SHEET	TITLE
E001	ELECTRICAL LEGEND
E101	LIGHTING SITE PLAN - PHASE 1
E102	HORIZONTAL LIGHTING PHOTOMETRICS - PHASE 1 AREA A
E103	HORIZONTAL LIGHTING PHOTOMETRICS - PHASE 1 AREA B
E104	VERTICAL LIGHTING PHOTOMETRICS - PHASE 1 AREA A
E105	VERTICAL LIGHTING PHOTOMETRICS - PHASE 1 AREA B
E106	LIGHTING SITE PLAN - PHASE 2 WEST
E107	LIGHTING SITE PLAN - PHASE 2 EAST
E108	HORIZONTAL LIGHTING PHOTOMETRICS - PHASE 2 AREA A
E109	HORIZONTAL LIGHTING PHOTOMETRICS - PHASE 2 AREA B
E110	HORIZONTAL LIGHTING PHOTOMETRICS - PHASE 2 AREA C
E111	VERTICAL LIGHTING PHOTOMETRICS - PHASE 2 AREA A
E112	VERTICAL LIGHTING PHOTOMETRICS - PHASE 2 AREA B
E113	VERTICAL LIGHTING PHOTOMETRICS - PHASE 2 AREA C

**BRIARGATE PKWY LIGHTING**

REVISIONS  
MARK DATE COMMENT  
1 03/26/2026 ISSUE FOR PERMIT

**HORIZONTAL LIGHTING PHOTOMETRICS - PHASE 1 AREA A**

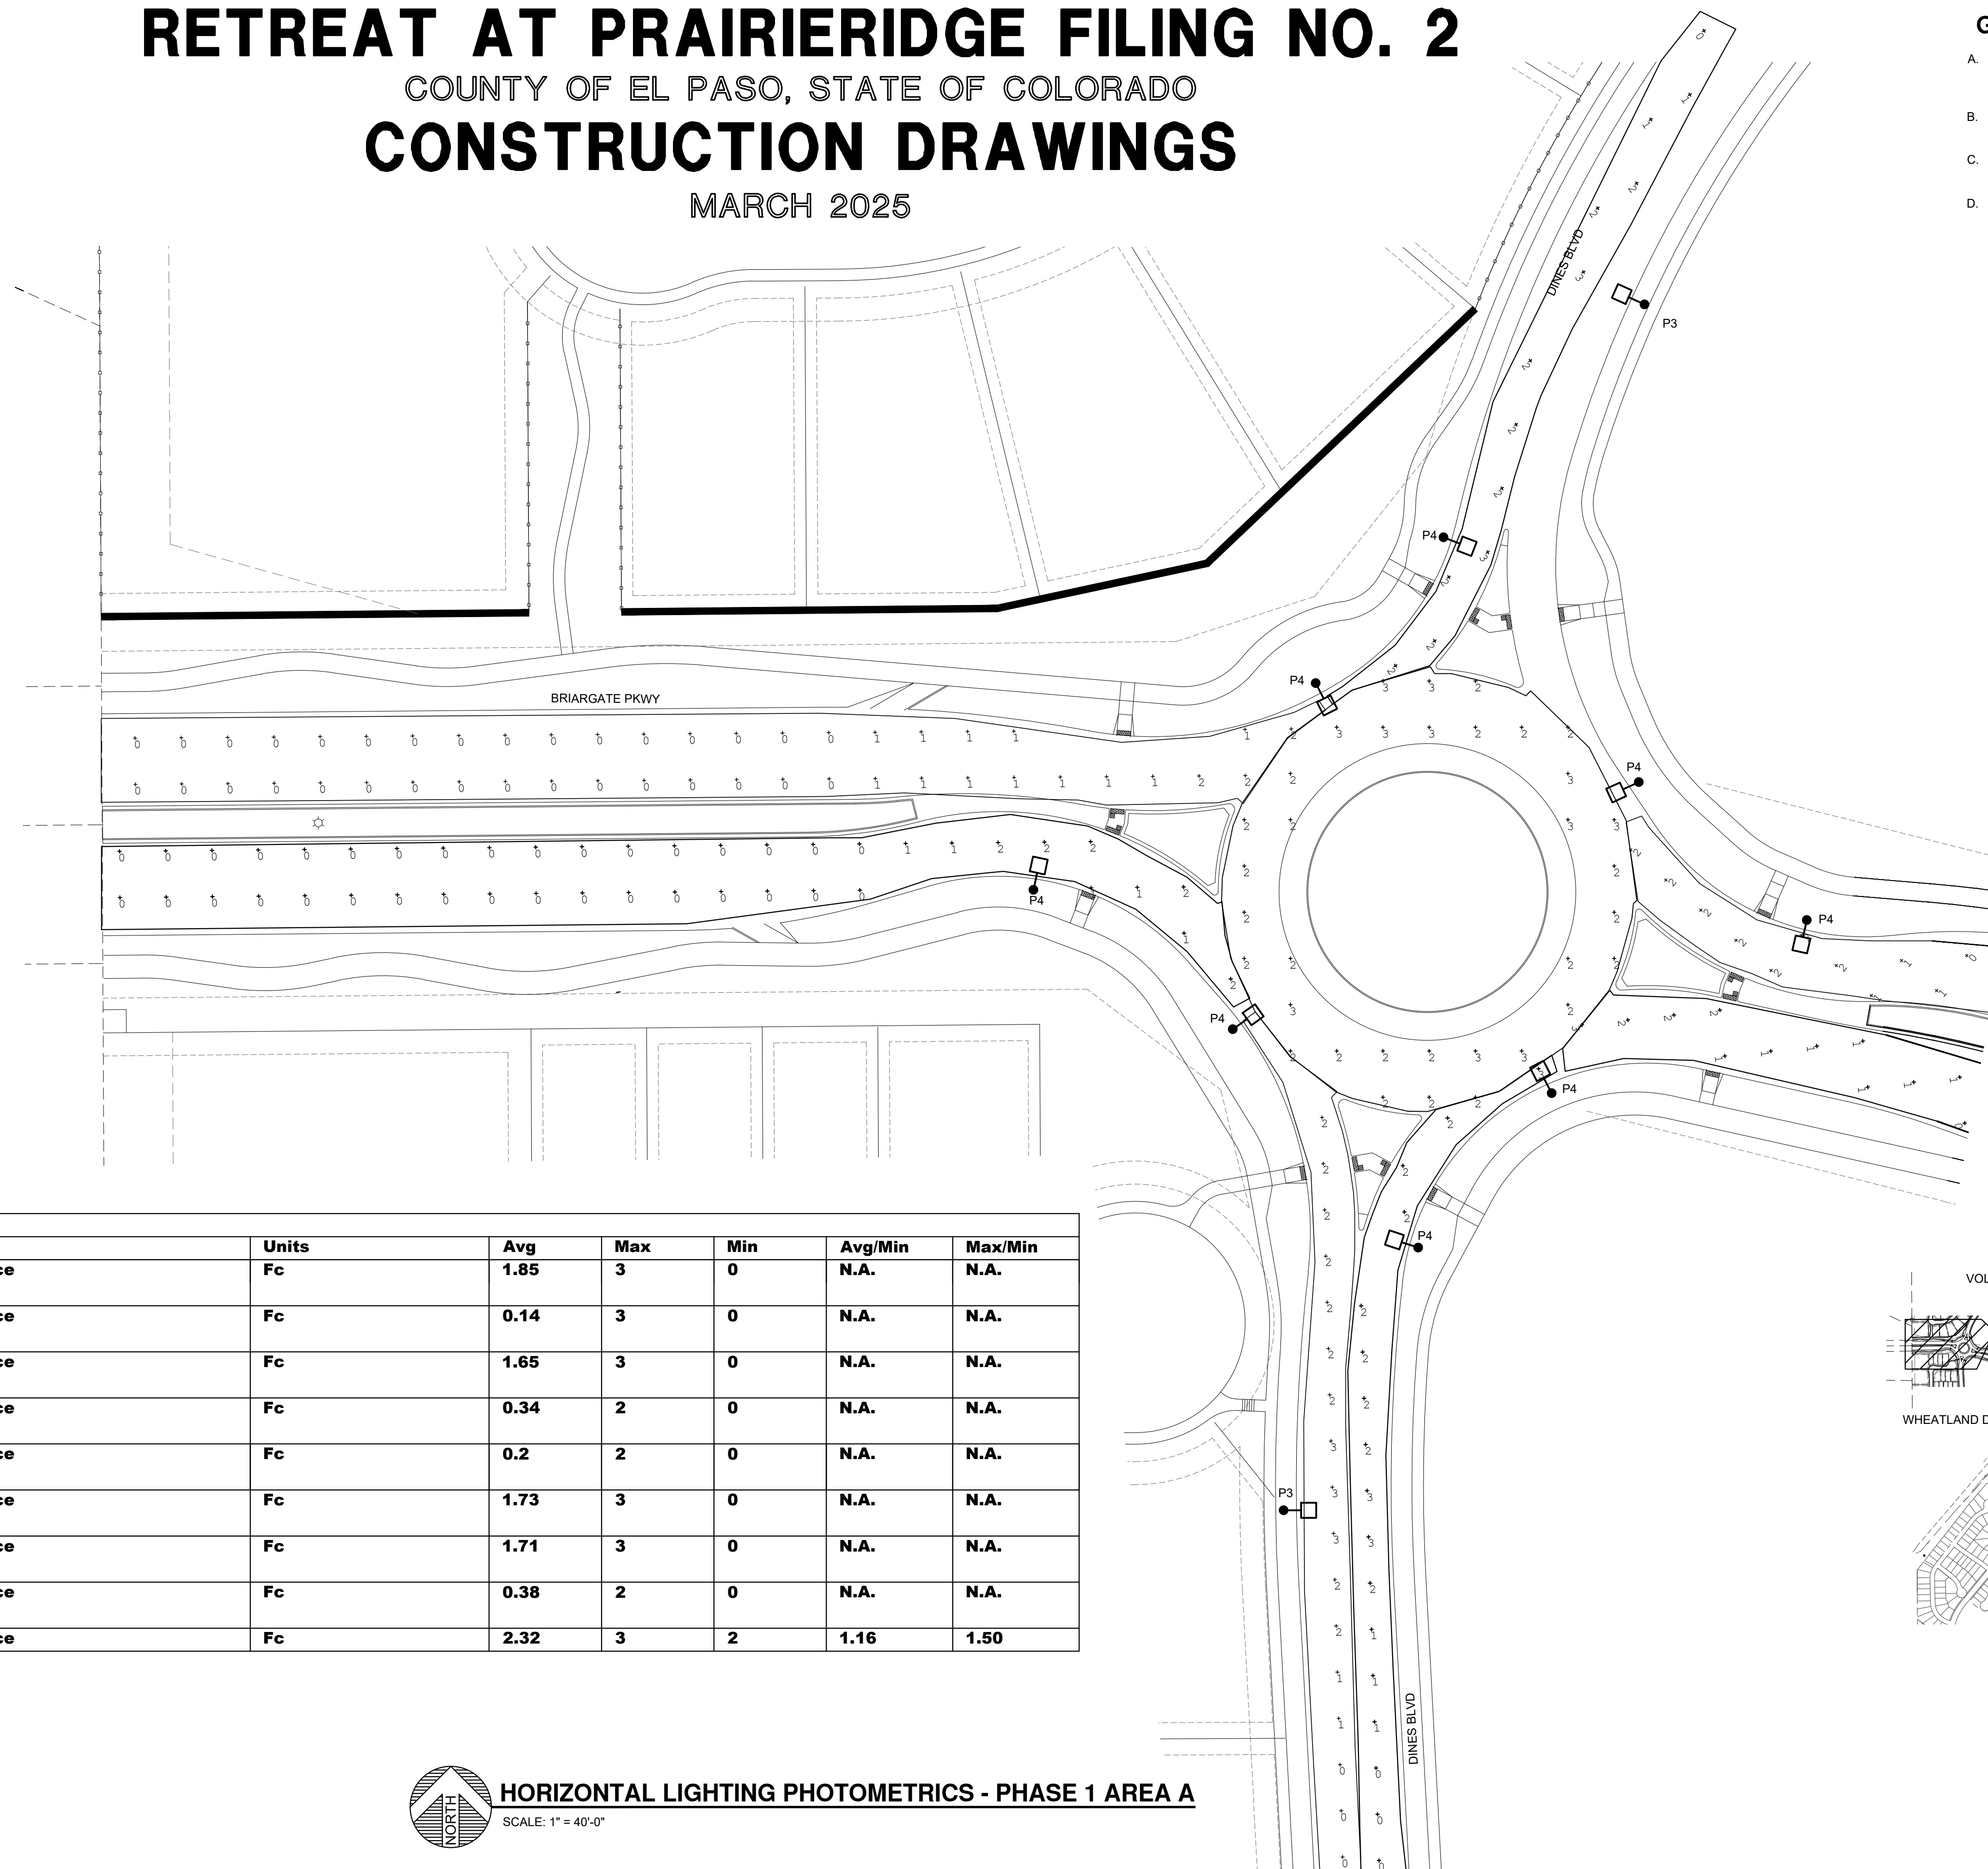
any lighting planned on Briargate?

consider relocating these closer to the pedestrian crossings
